28th March 2012

Application for Householder Planning Permission

Development Rear first floor extension to extend bedroom & provide en-suite facility
Location 140 Barnham Road Barnham

REAR ELEVATION

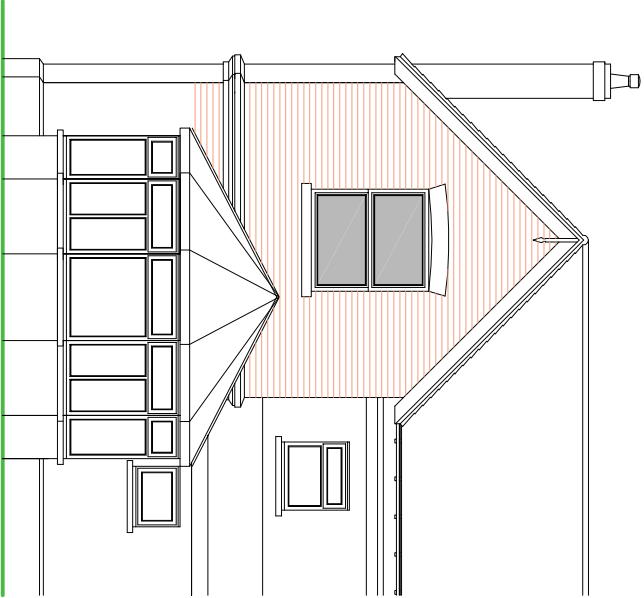
Please provide 1 electronic or 3 paper copies of revised existing and proposed floor plans/elevations. The existing and proposed rear elevations still show 2 windows on the first floor level, however only 1 window is shown on the existing and proposed first floor plans. Please amend.
